DOC16/338445-04
08_0150 MOD 2

BULLI SEAM OPERATIONS PROJECT MODIFICATION (08_0150 MOD 2)

Figure 3-1 Monitoring Locations

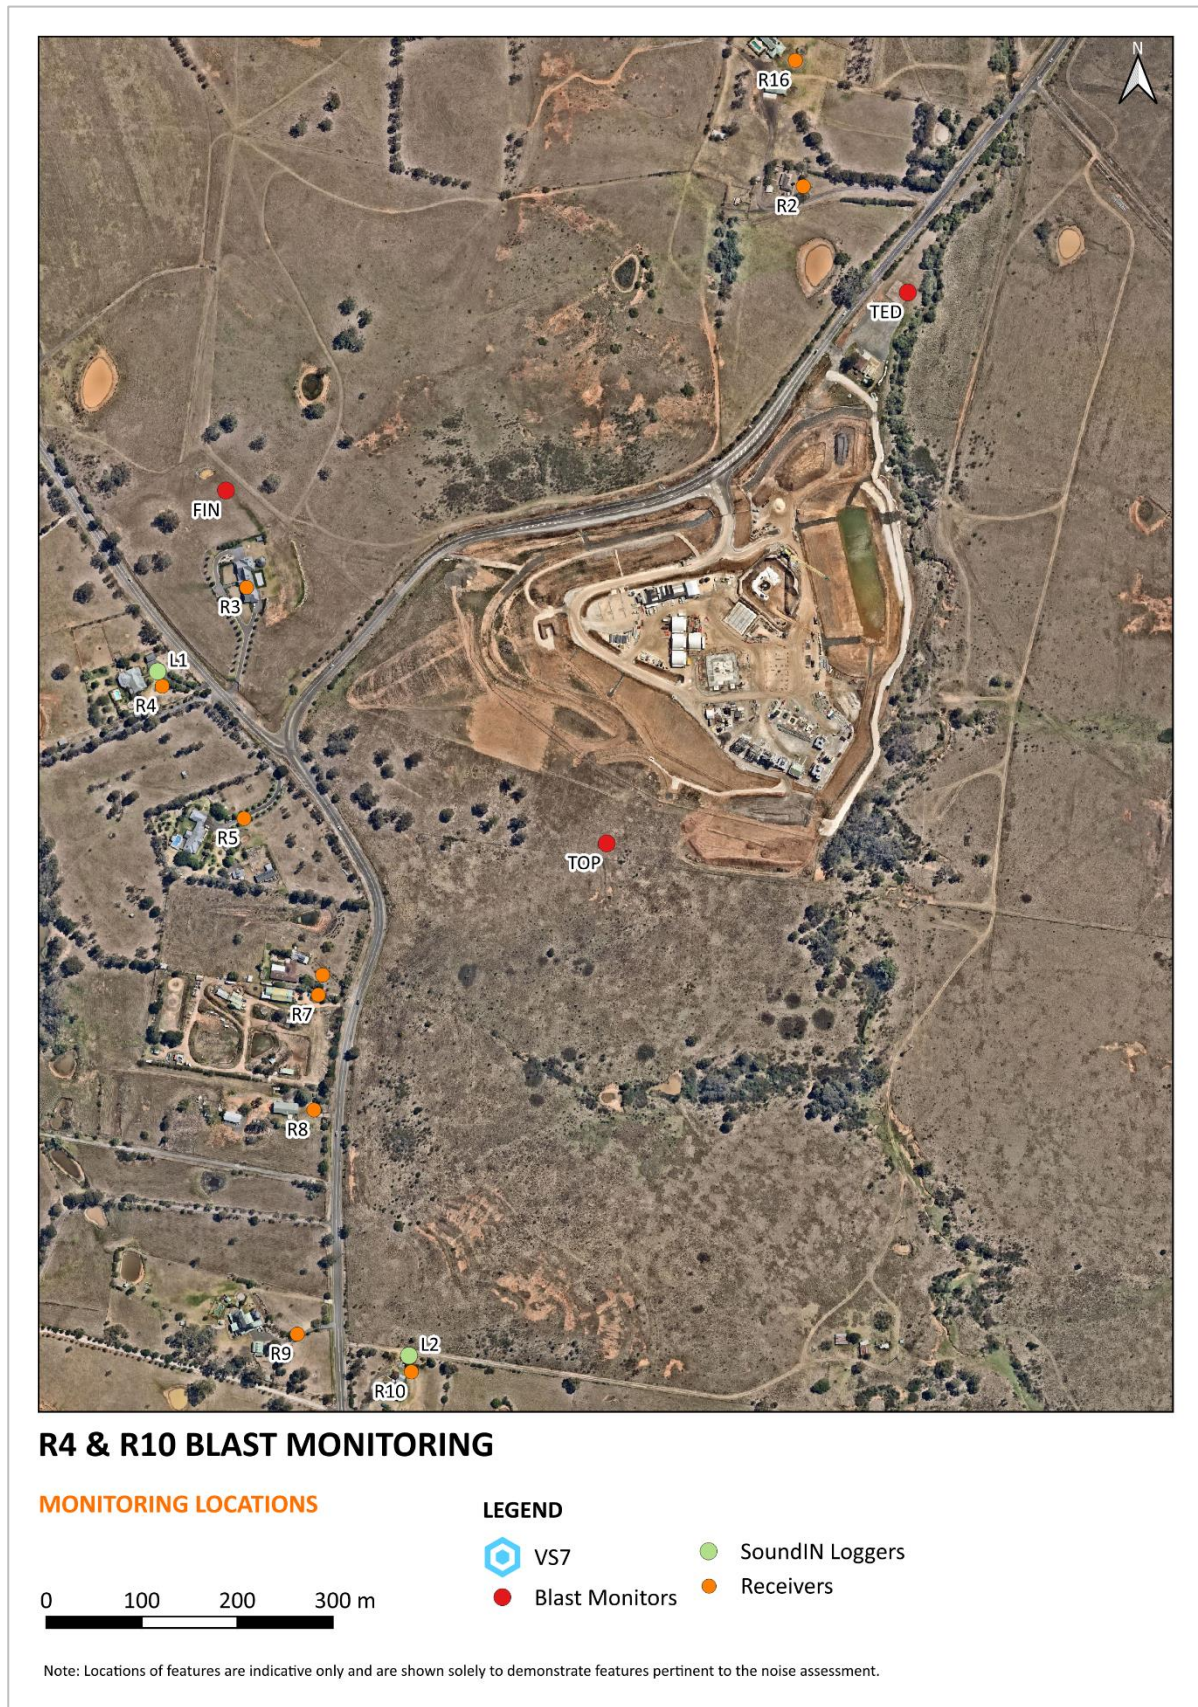
- In relation to noise, table 5.1 of the Wilkinson Murray noise report predicts that two residential noise receptors at locations 78 and 218 are likely to be highly noise affected >75 dBA. Receiver 78 will experience the highest noise levels of 82 – 86 dBA for a period of up to a week. Receivers 218 and 280 are expected to experience high noise levels (RBL + 10 dBA) over a 6 week period during excavation, boring and refilling. For reference, please see Figure 3-1 below taken from the report.

- Noise mitigation proposed for site 78 is to turn off or move any unnecessary equipment away from the site. No mitigation measures are listed for sites 218 or 280.
- The Interim Construction Noise Guideline (ICNG) states that where receivers are likely to be highly noise affected, the proponent must examine reasonable and feasible work practices and mitigation measures to minimise noise.
- The EPA recommends that the proponent revisit planned work practices to identify more significant measures to minimise noise impacts on residents at the affected locations 78, 218 and 280 (see Section 6 of the ICNG).
